from
**Southern
Water**

PLAN-027564

Proposal: Replace burnt down cottage with a similar sized single storey property - This is a Departure from the Development Plan.

Site: Mow Cottage Worms Lane, Felpham, PO22 6BD.
FP/64/19/PL

SITE PLAN 1:500 @ A3

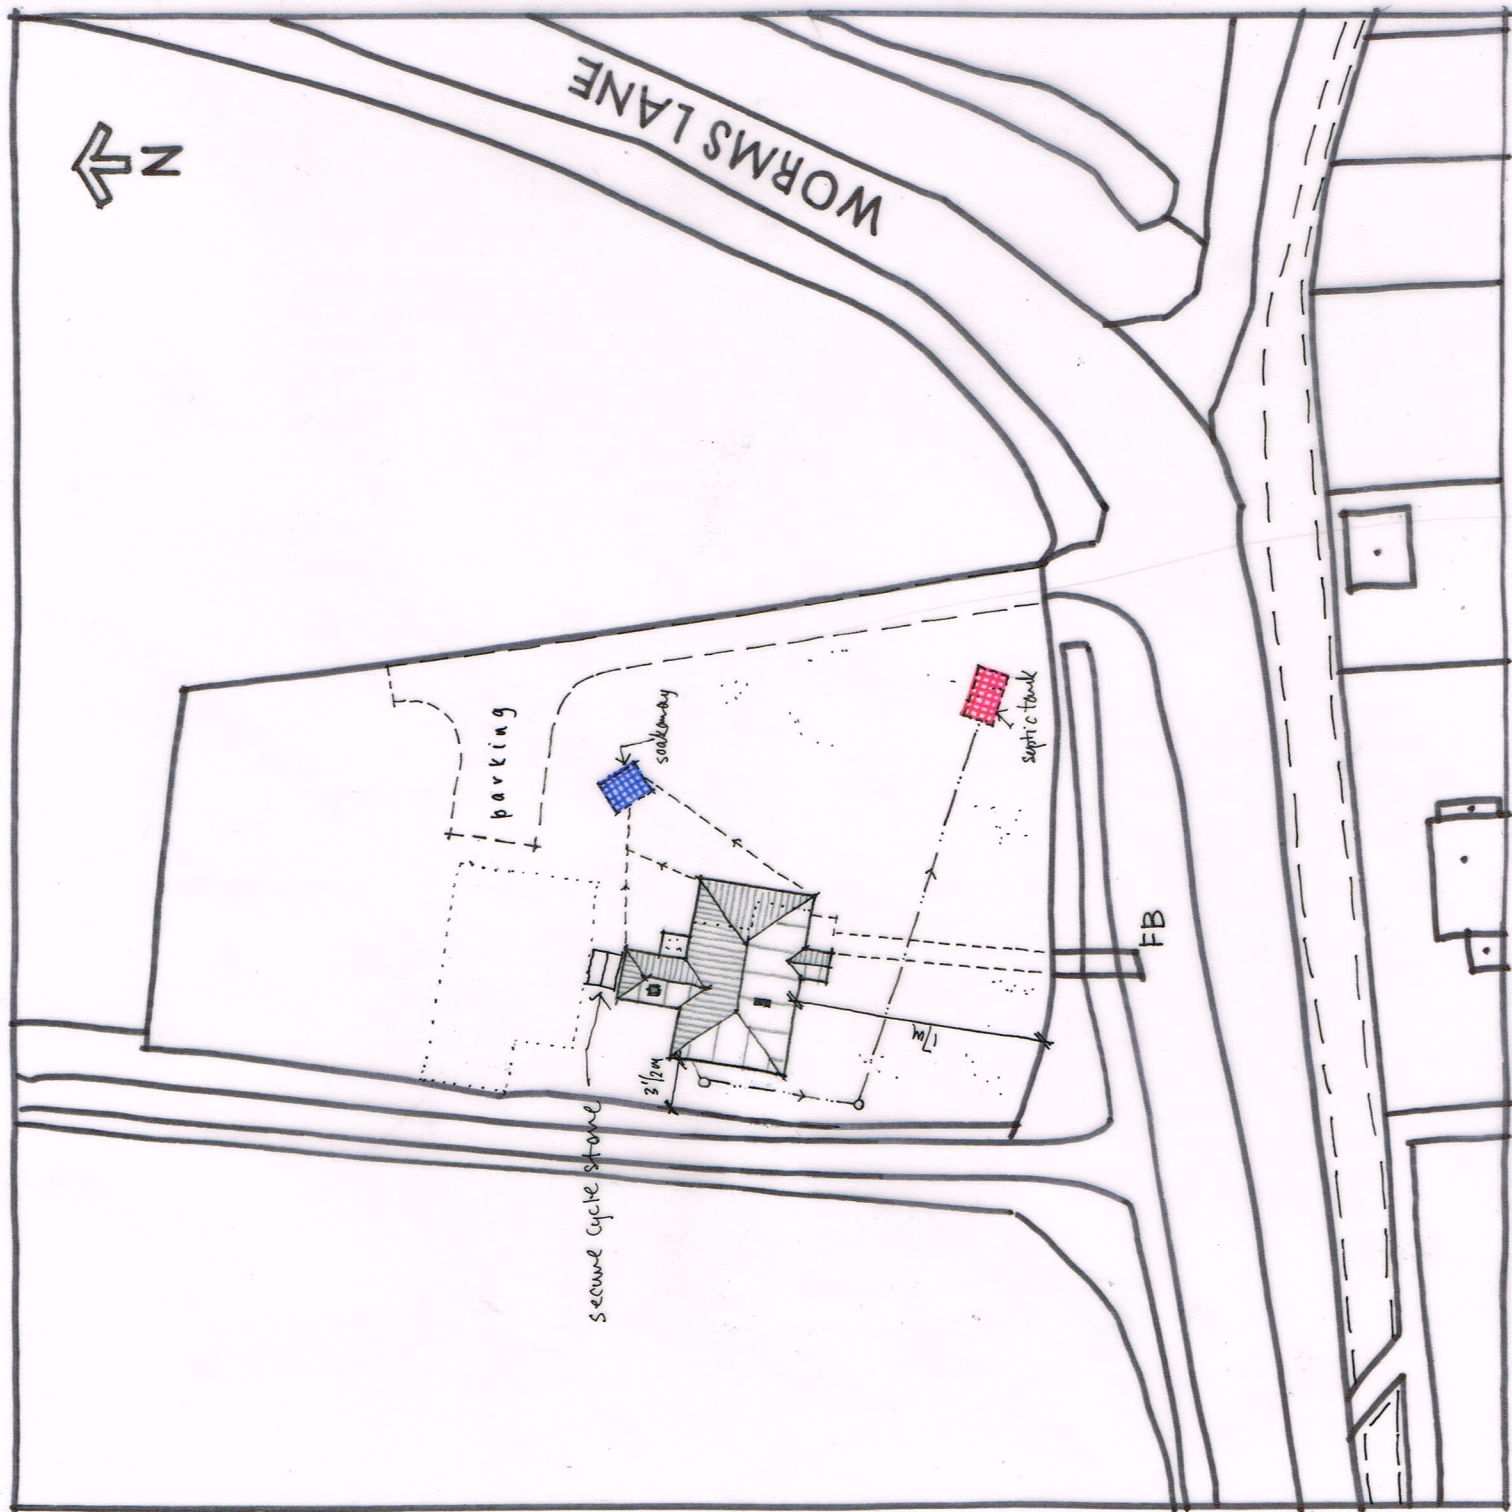
Southern Water would not support the proposals for septic tank or private treatment plant in the presence of public foul sewerage network in the close vicinity of the development site. The foul sewerage shall be disposed in accordance with Part H1 of Building Regulations hierarchy.

Southern Water requires a formal application for a connection to the foul sewer to be made by the applicant or developer.
